From: Amanda Scholes on behalf of Planning.Responses
Sent: 20 May 2019 11:29
To: Planning Scanning
Subject: FW: FG/220/18
Attachments: IMG_20190325_100113.jpg; IMG_20190325_100047 (1).jpg

From: [REDACTED]
Sent: 25 March 2019 13:54
To: Andrew Wood
Subject: FG/220/18

EXISTING POND ACCESS
PLAN

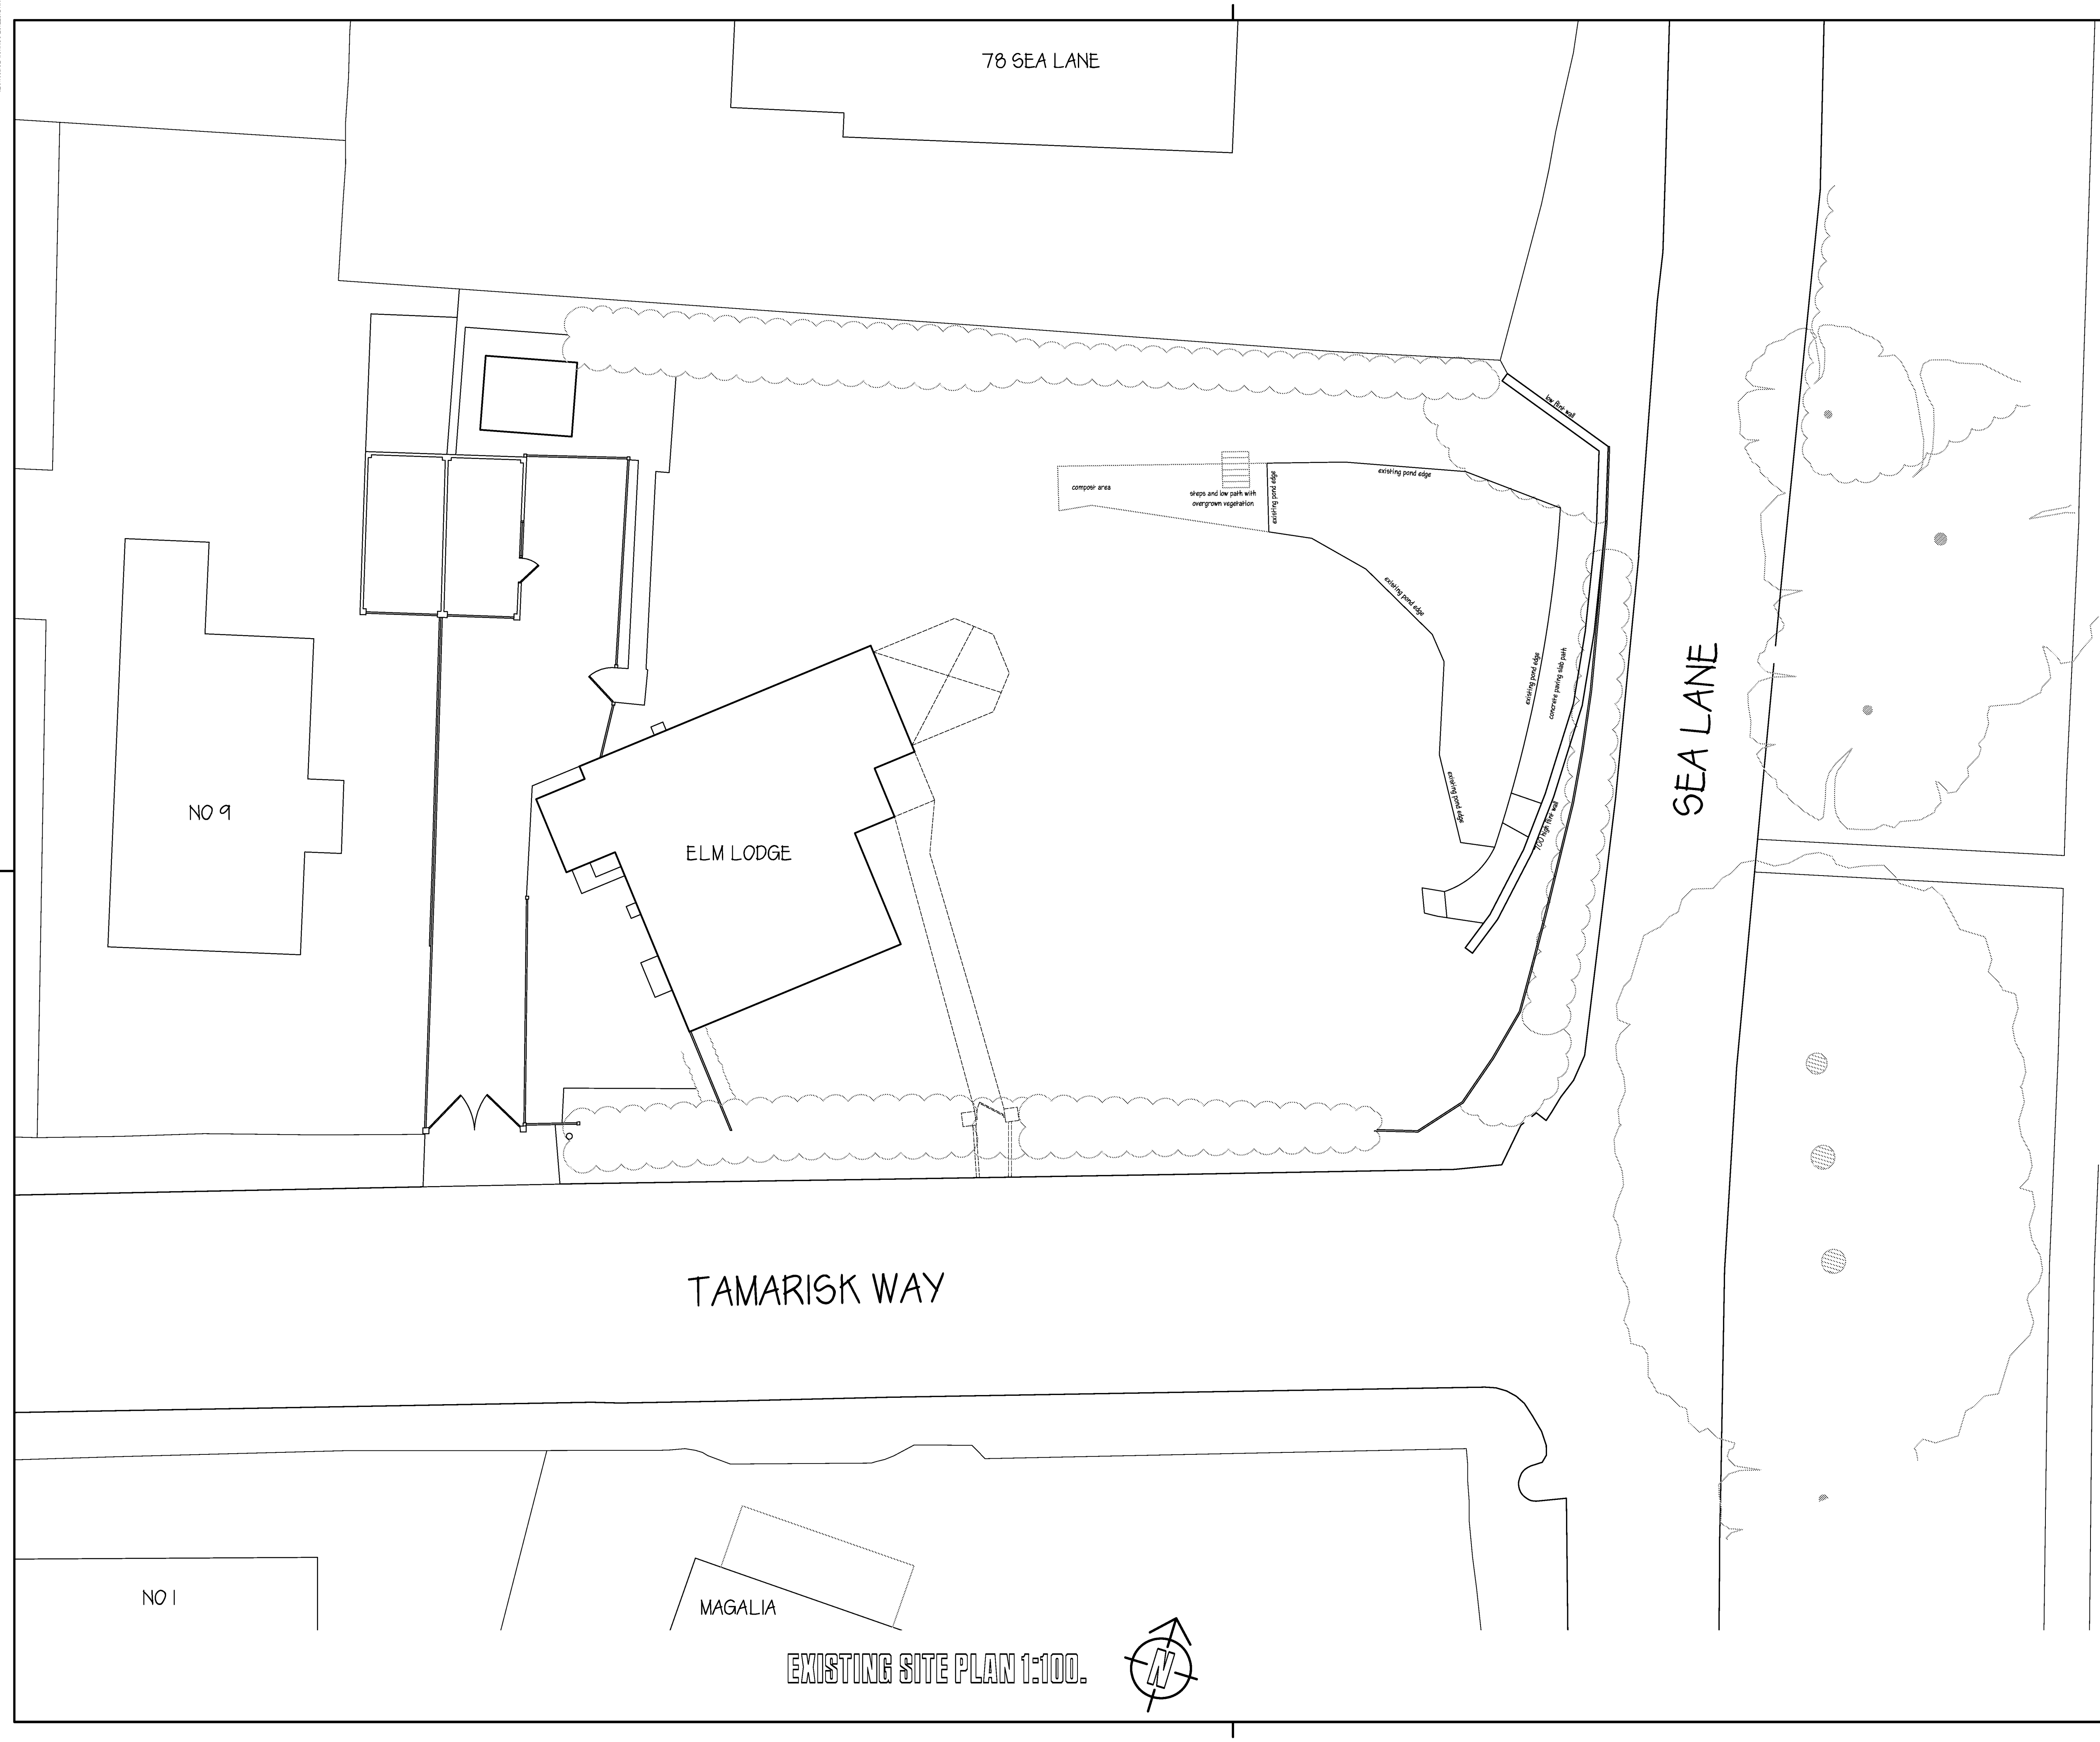
The latest report on this application states that there will be no change to the pond area and resubmitted plans show a clear area all round the pond.
However, the pond area extends fully to the boundary wall on the NE corner of the plot, allowing no easement(ref Laura Gibbons report). The extent of the pond is clearly illustrated in the attached photos and on the land registry document already submitted. This further suggests that notwithstanding small adjustments to the siting of the new building, there is no alleviation to the threat to the drainage system.

Drawing Title **PROPOSED POND ACCESS
PLAN**

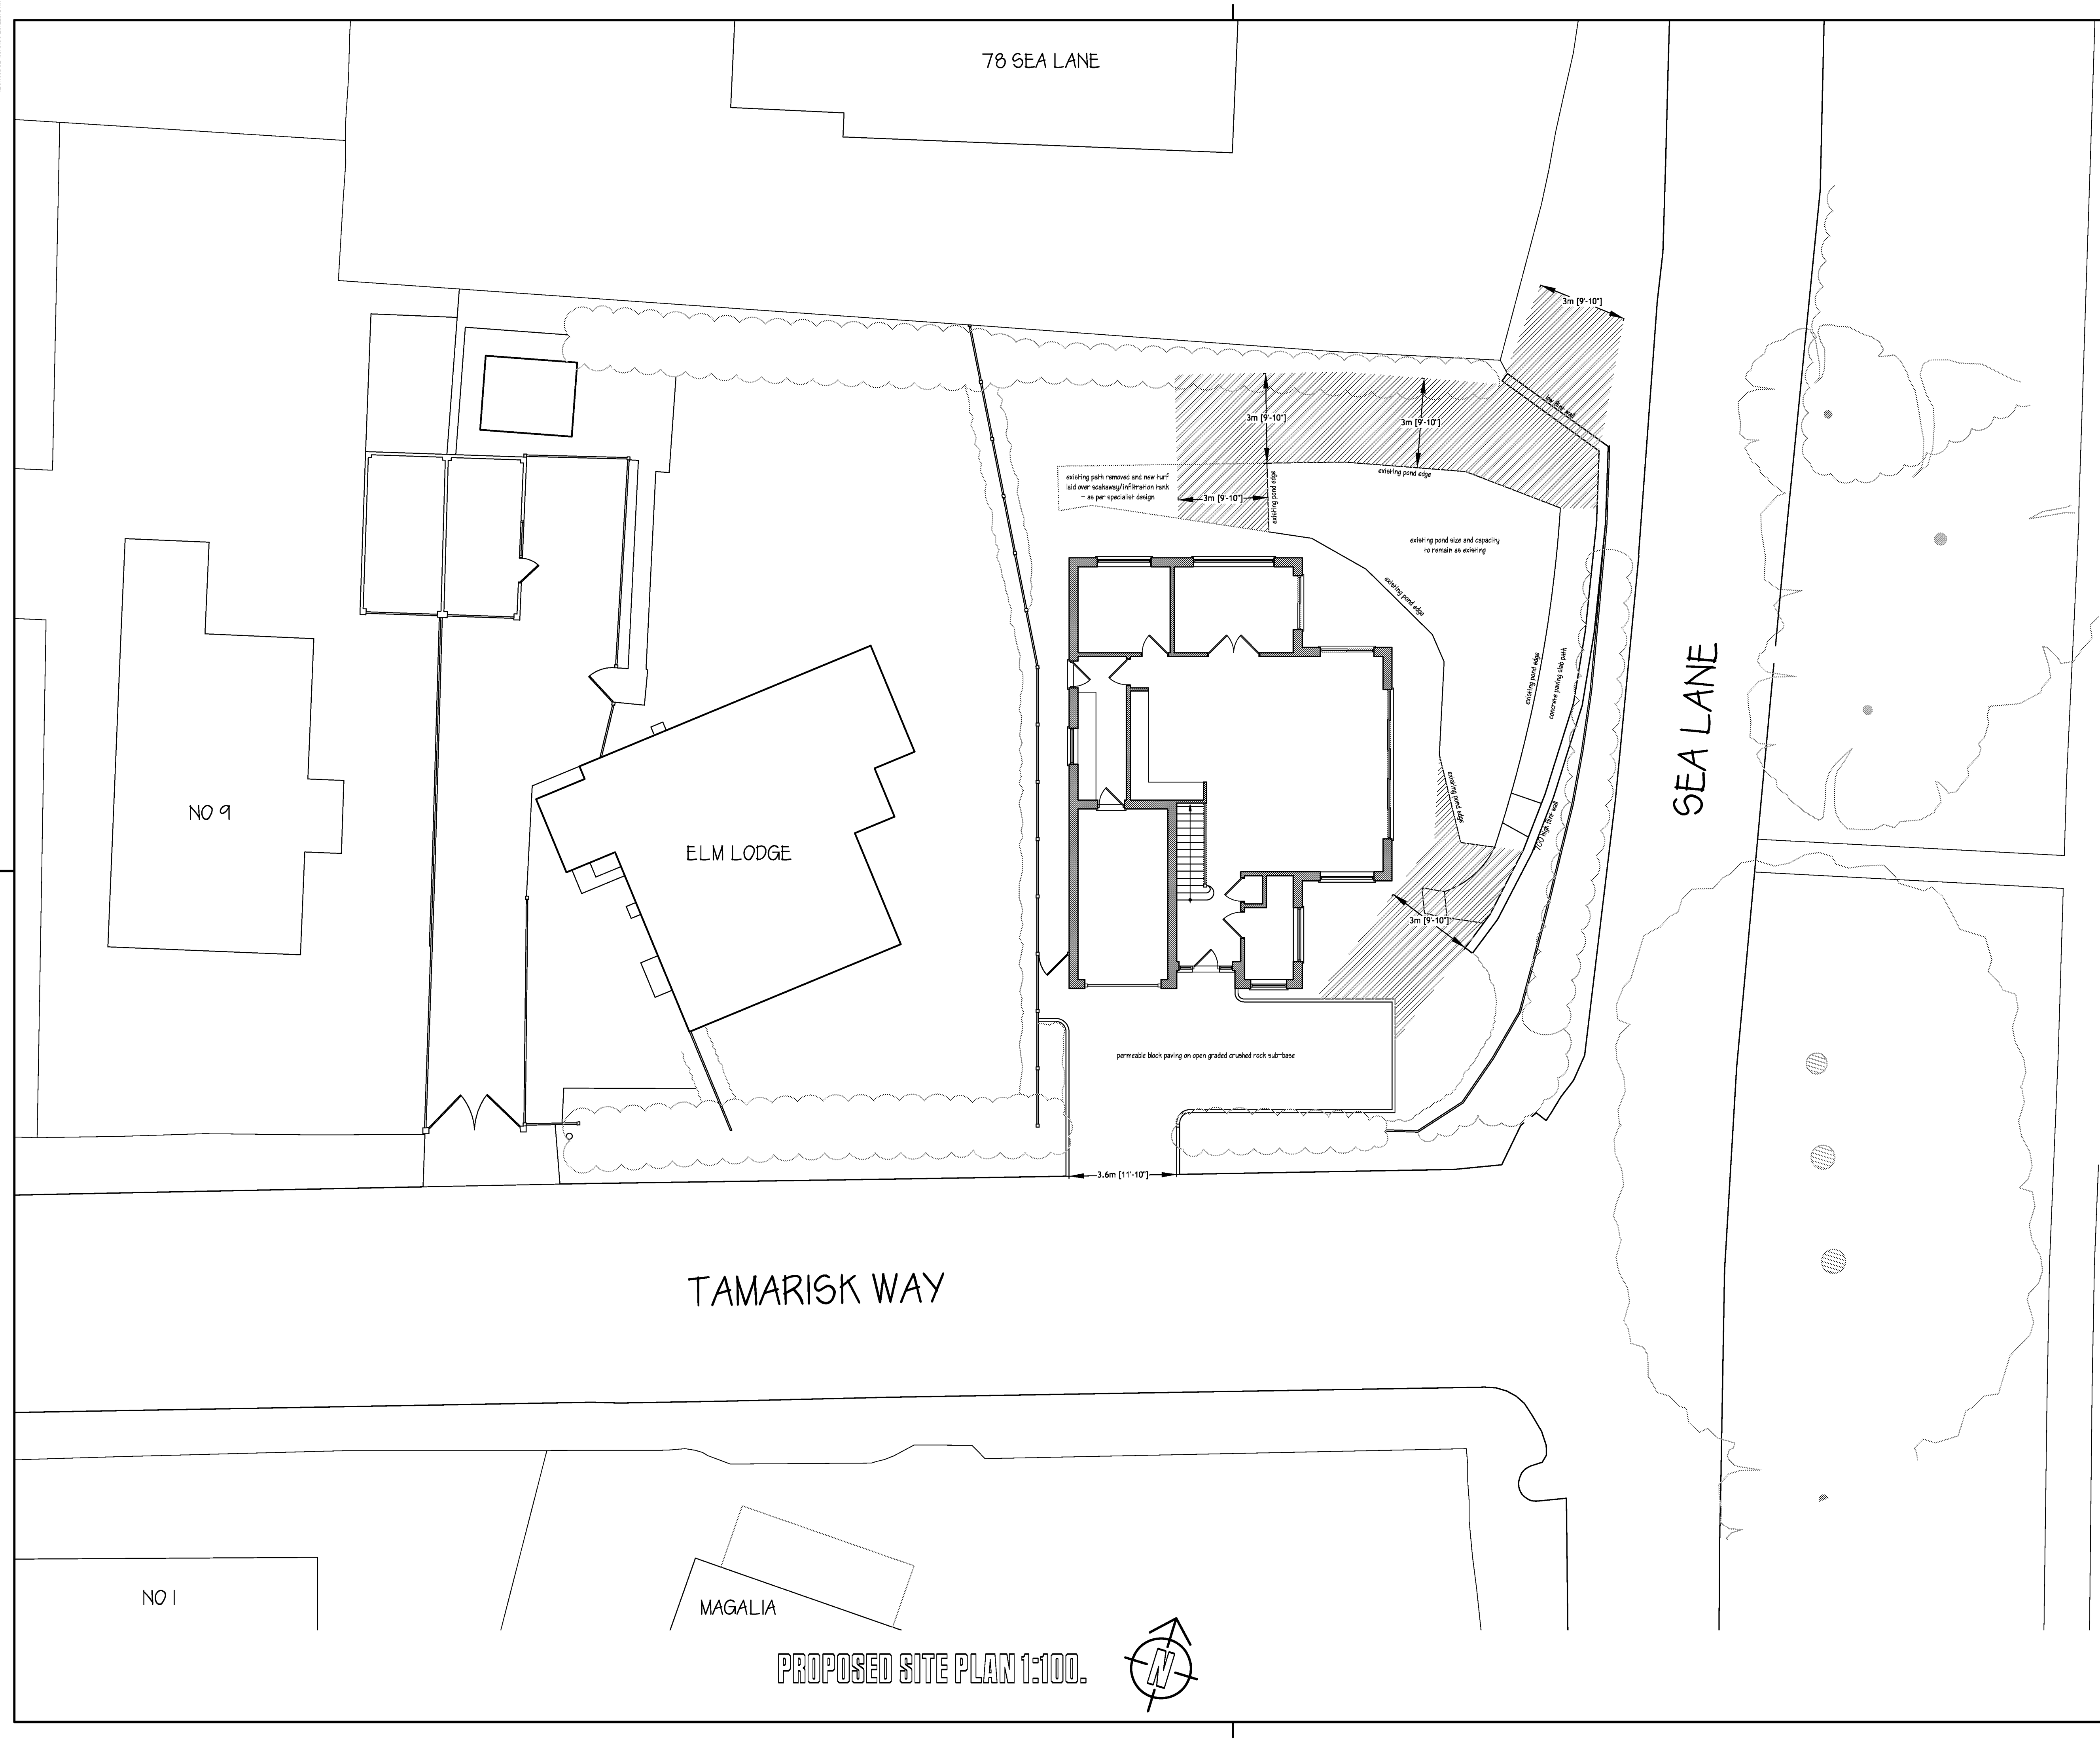
We would suggest that this, combined with the large size of the pond, severely restricts the amount of land available to build on.
